**Consultation Response from: KC Environmental Health (Pollution & Noise Control)**

**2024/90072 land at Bradley Villa Farm, Bradley Road, Bradley, Huddersfield, HD2 2JX**

**Discharge of conditions 13 (cycle parking), 14 (electric vehicle charging), 16 (waste management), 33 (air source heat pumps) and 36 (external lighting) of previous permission 2021/92086 for erection of 277 residential dwellings and associated infrastructure and access**

**Date Responded:**  
**29<sup>th</sup> January 2024**

MARKETING NAME: -
 PROJECT: BRADFORD ROAD HUDDERSFIELD
 TITLE: PROPOSED EV CHARGING PLAN

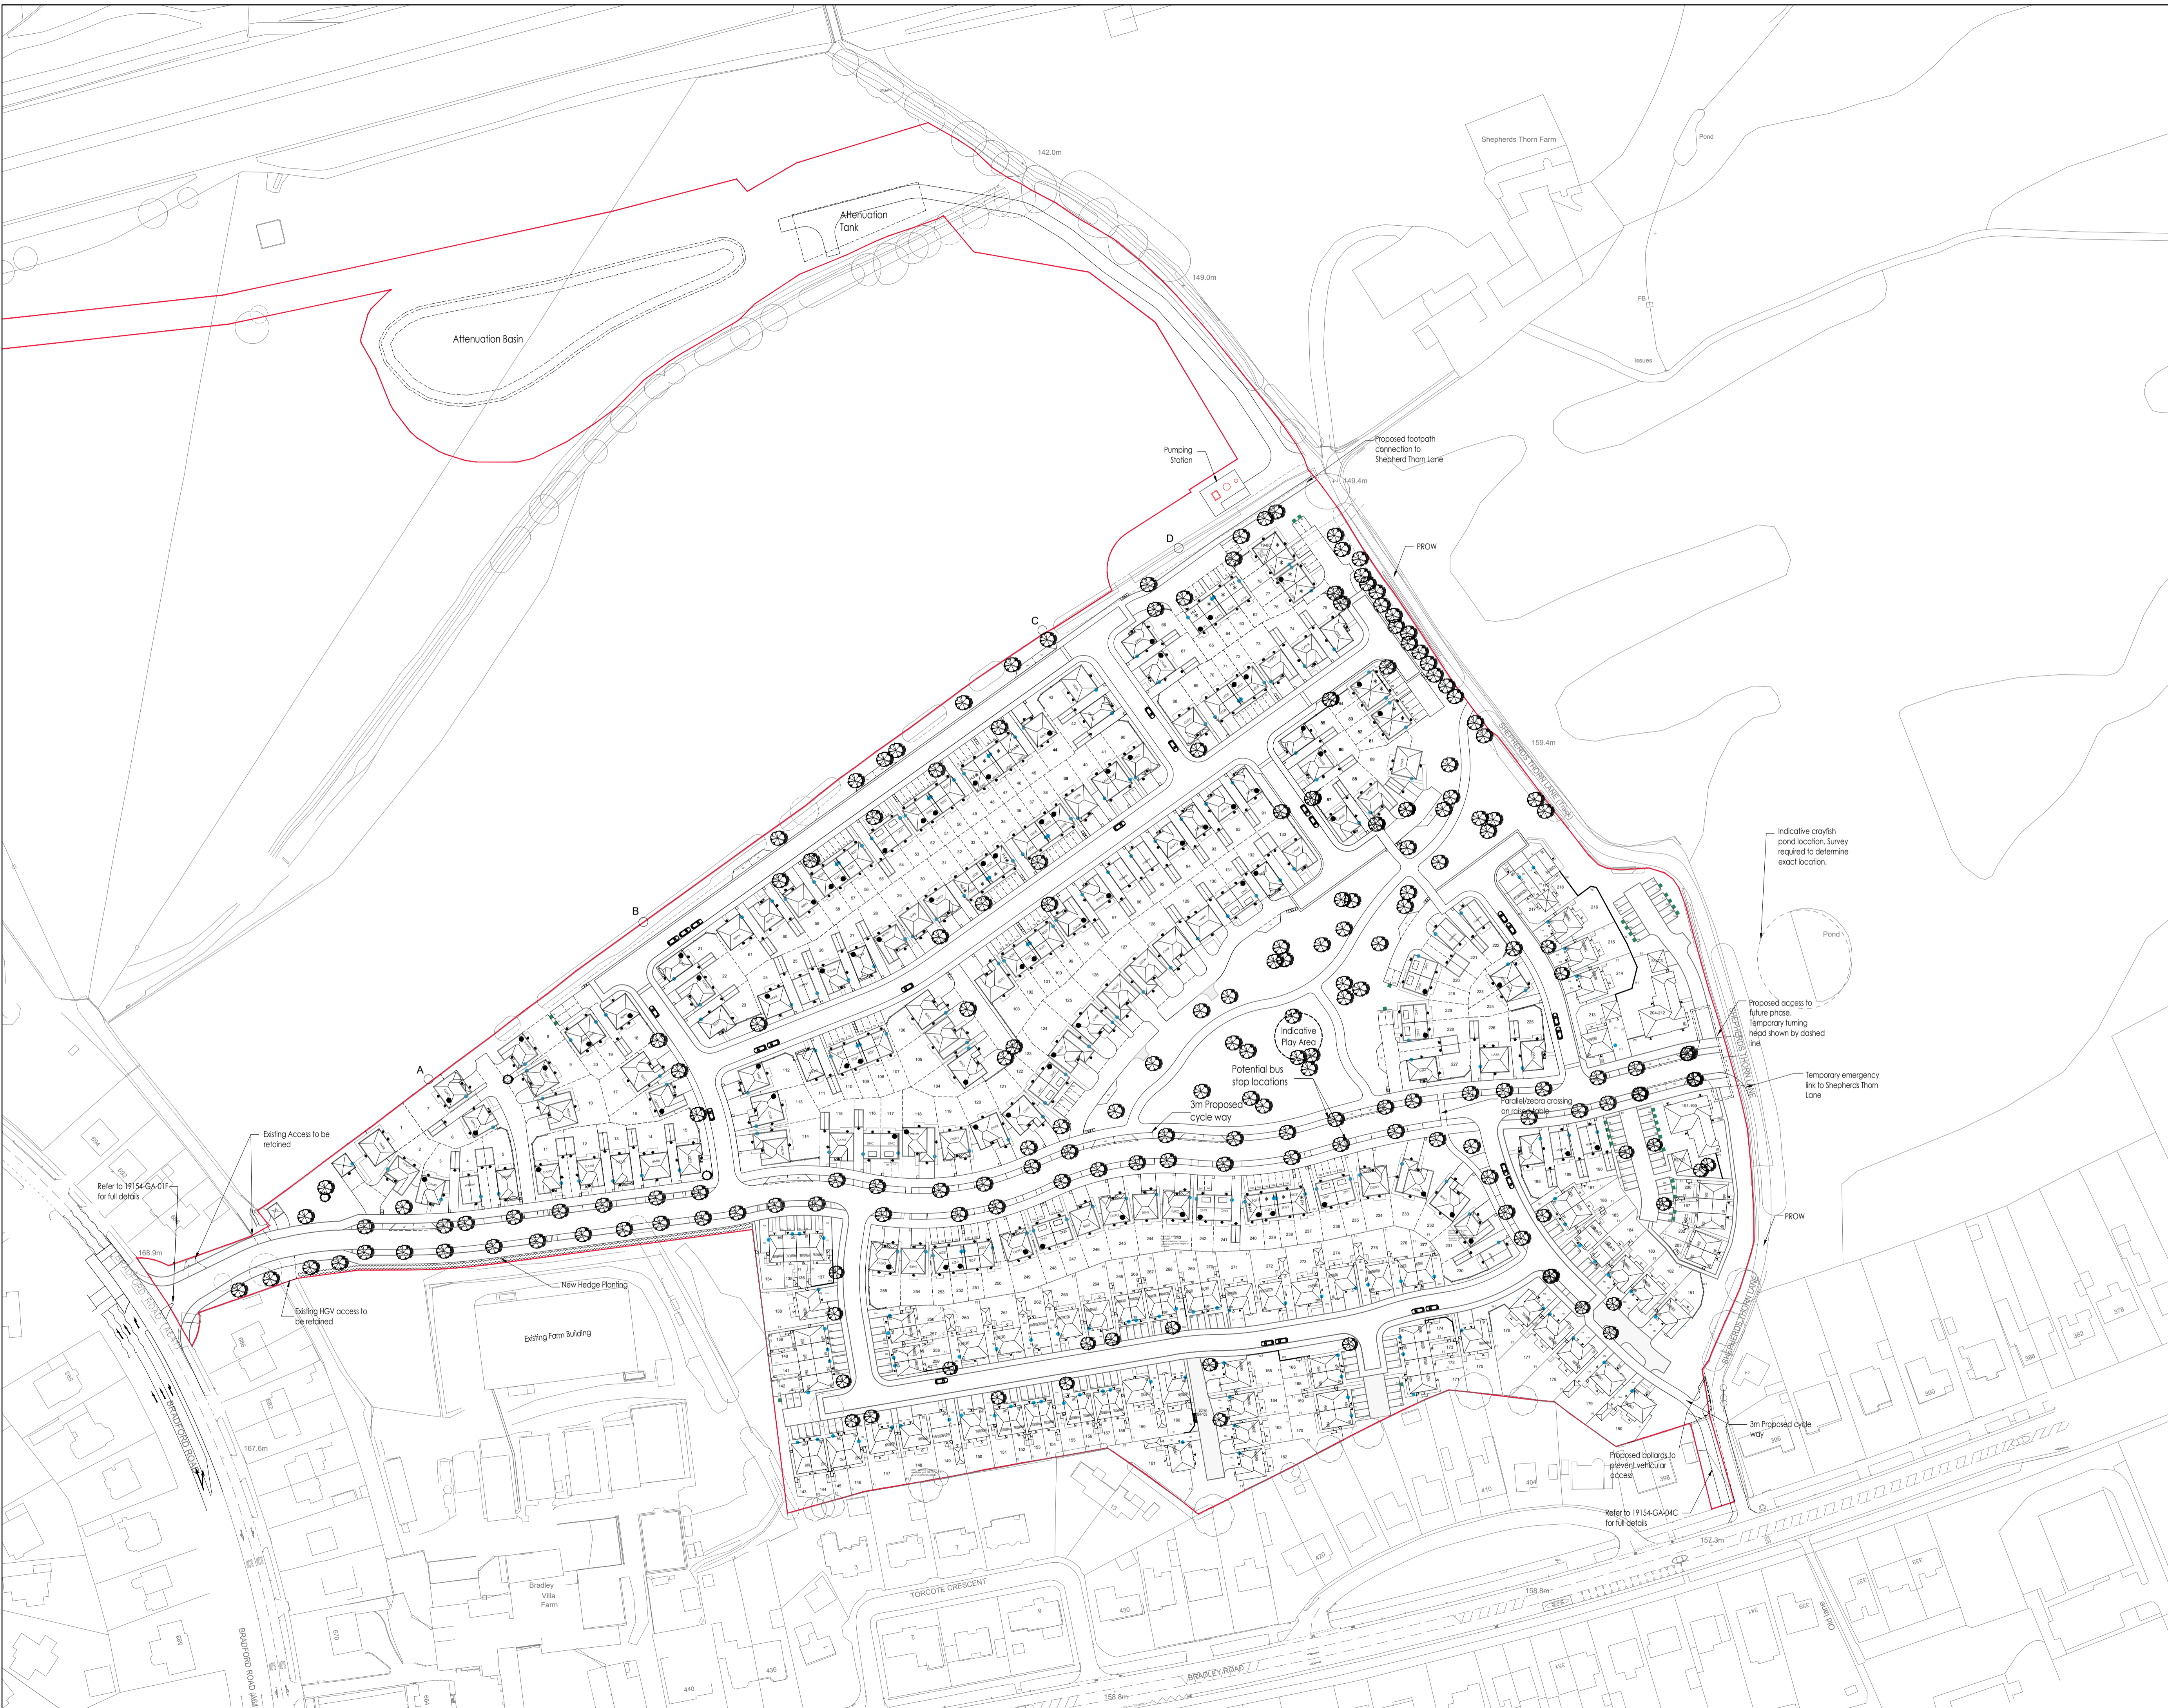
To discharge condition 14, a plan by Redrow Homes titled proposed EV Charging Plan (ref: BVF-16-02-07) (dated 22.03.21) has been submitted. The plan shows the position of the externally mounted and post mounted EV charging points across the development site. The annotation on the plan indicated that the proposal is to install Podpoint Mode 3 32 Amp charge points. We accept the information that has been submitted.

We accept the information that has been submitted by Redrow Homes and recommend that Condition 14 is now discharged.
